**EPC STORMWATER REVIEW COMMENTS
 IN ORANGE BOXES WITH BLACK TEXT**

**EL PASO COUNTY
 STORMWATER MANAGEMENT PLAN CHECKLIST**

EPC Project Number: **PPR2315**

GRADING CUT/FILL AREAS

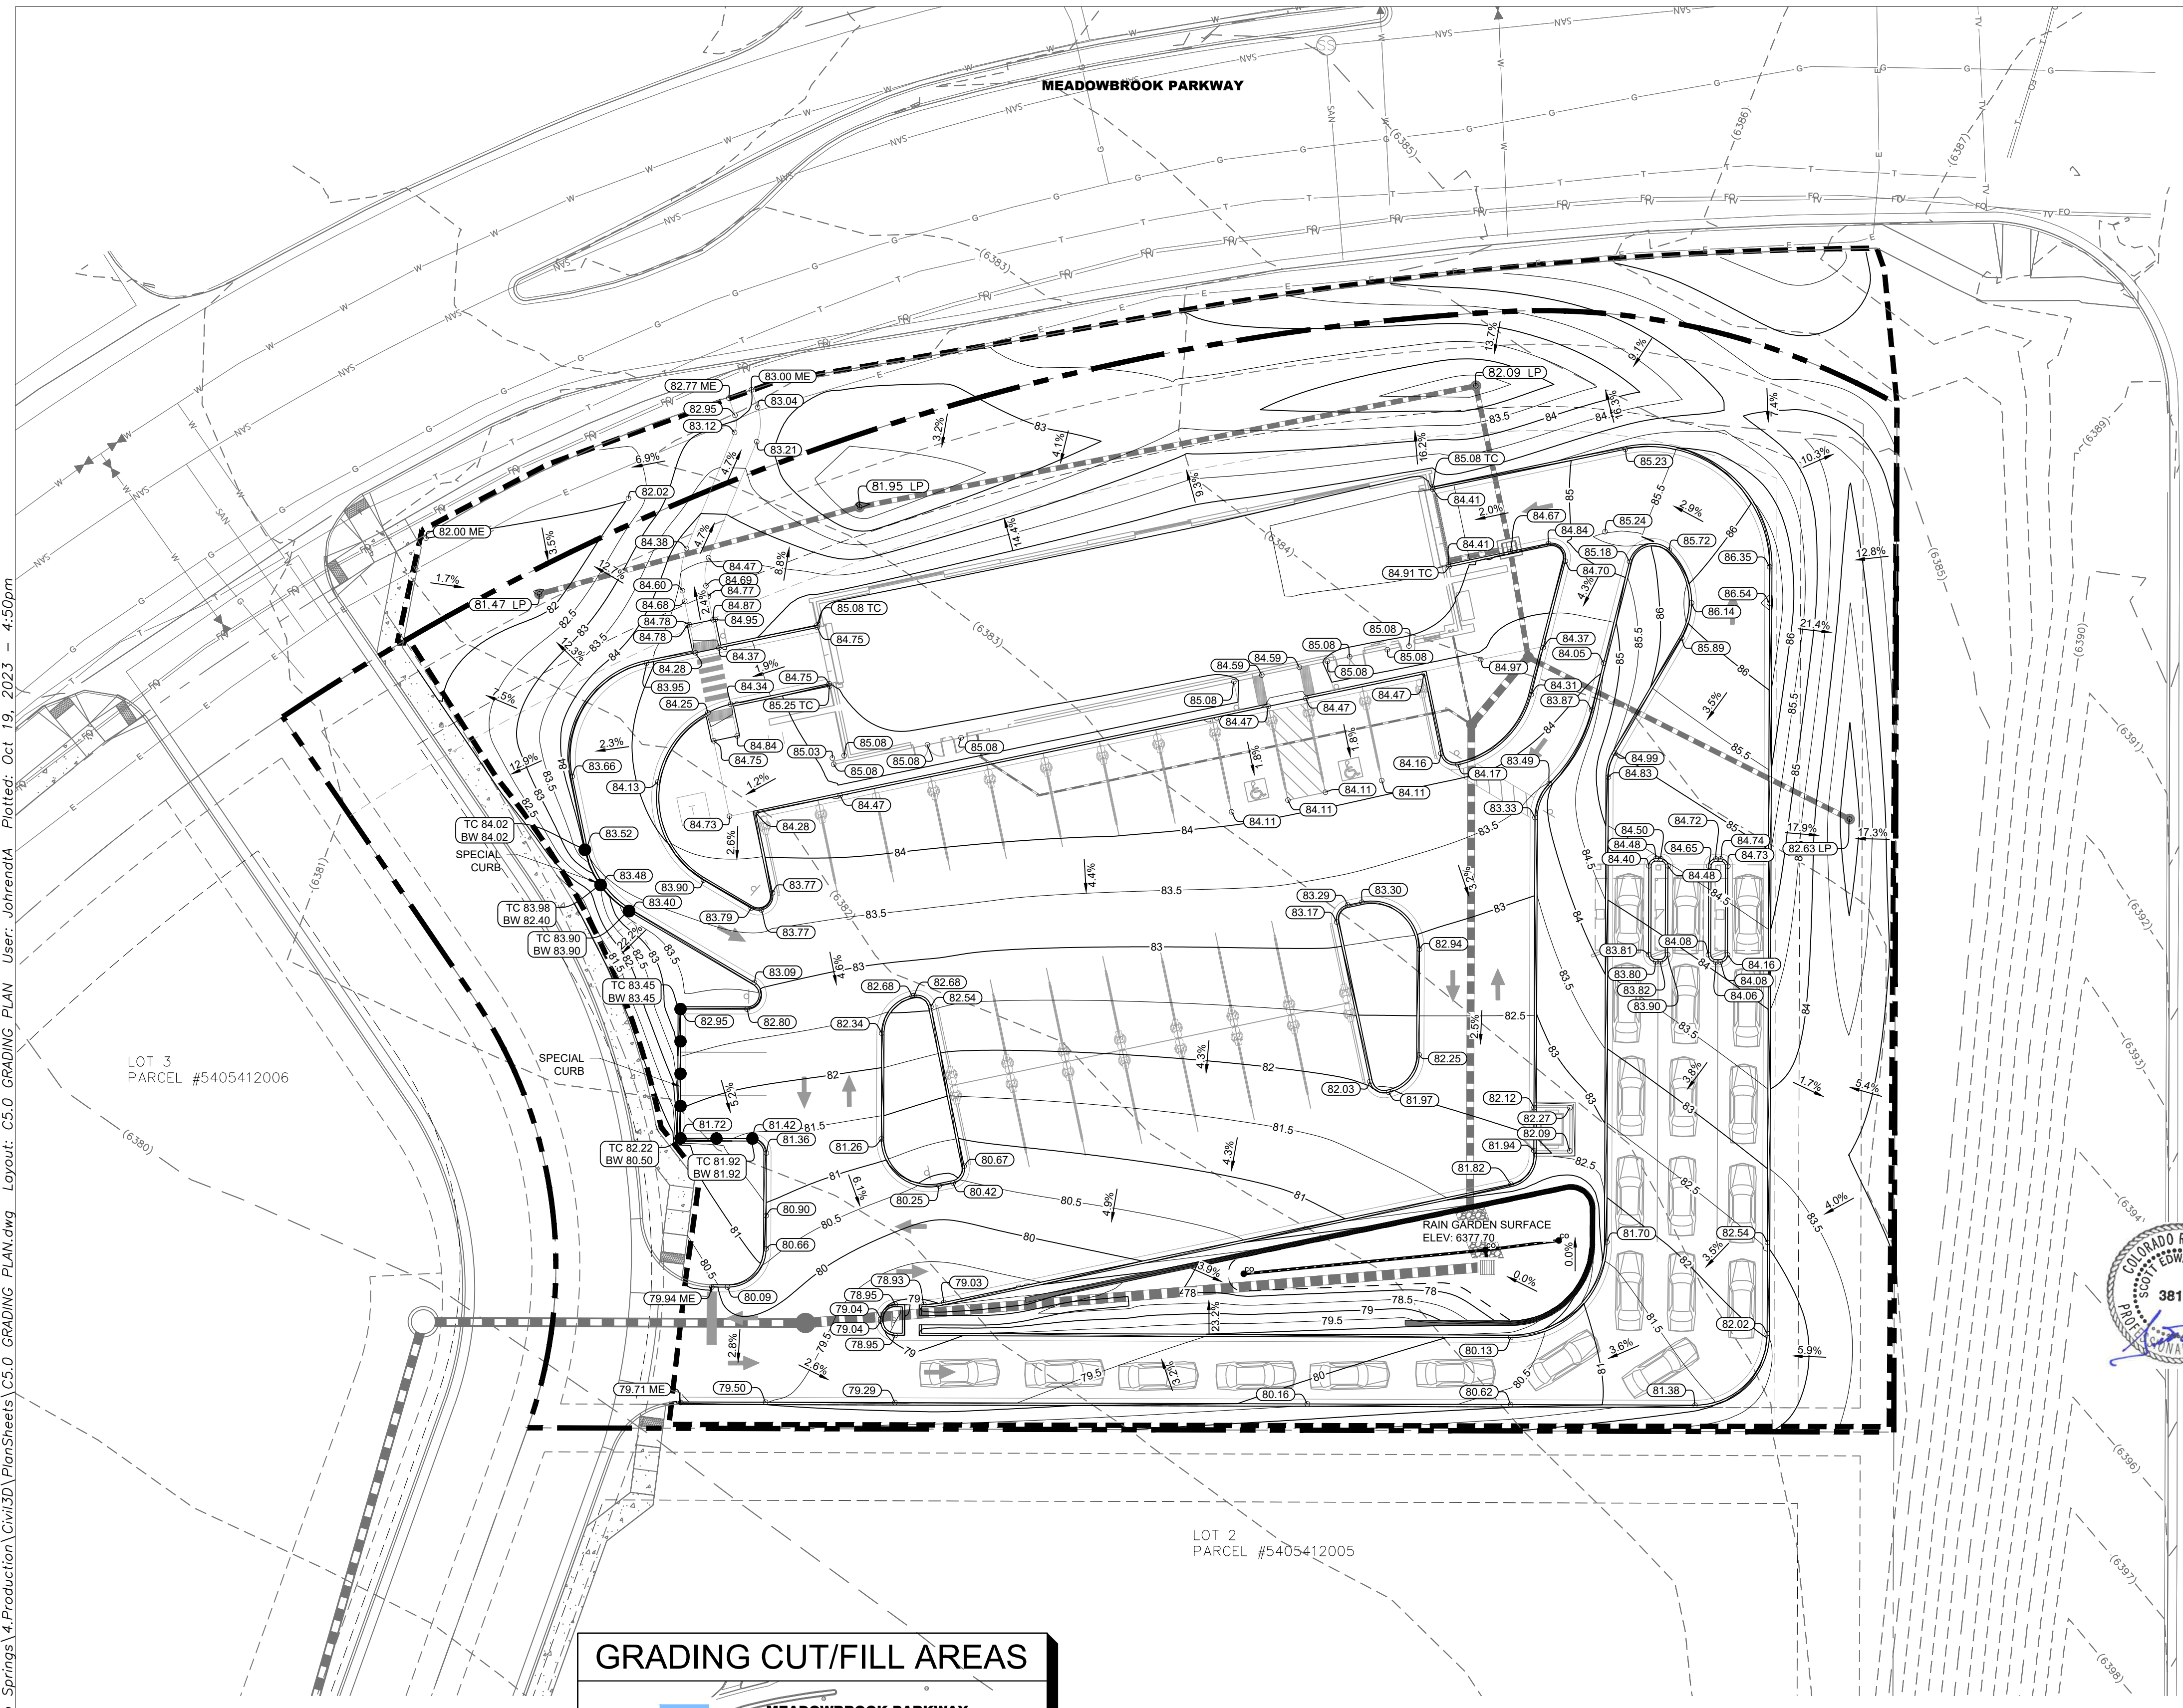
Applicant	EPC
17	SWMP Map to include:		
17a	construction site boundaries	X	Y
17b	flow arrows to depict stormwater flow directions	X	Y
17c	all areas of disturbance	X	Y
17d	areas of cut and fill	X	N
17e	areas used for storage of building materials, soils (stockpiles) or wastes	X	Y
17f	location of any dedicated asphalt / concrete batch plants	N/A	N
17g	location of all structural control measures	X	Y
17h	location of all non-structural control measures	X	N
17i	springs, streams, wetlands and other surface waters, including areas that require maintenance of pre-existing vegetation within 50 feet of a receiving water	N/A	Y
18	Narrative description of all structural control measures to be used. Modifications to EPC standard control measures must meet or exceed County-approved details	X	N
19	Description of all non-structural control measures to be used including seeding, mulching, protection of existing vegetation, site watering, sod placement, etc.	X	N
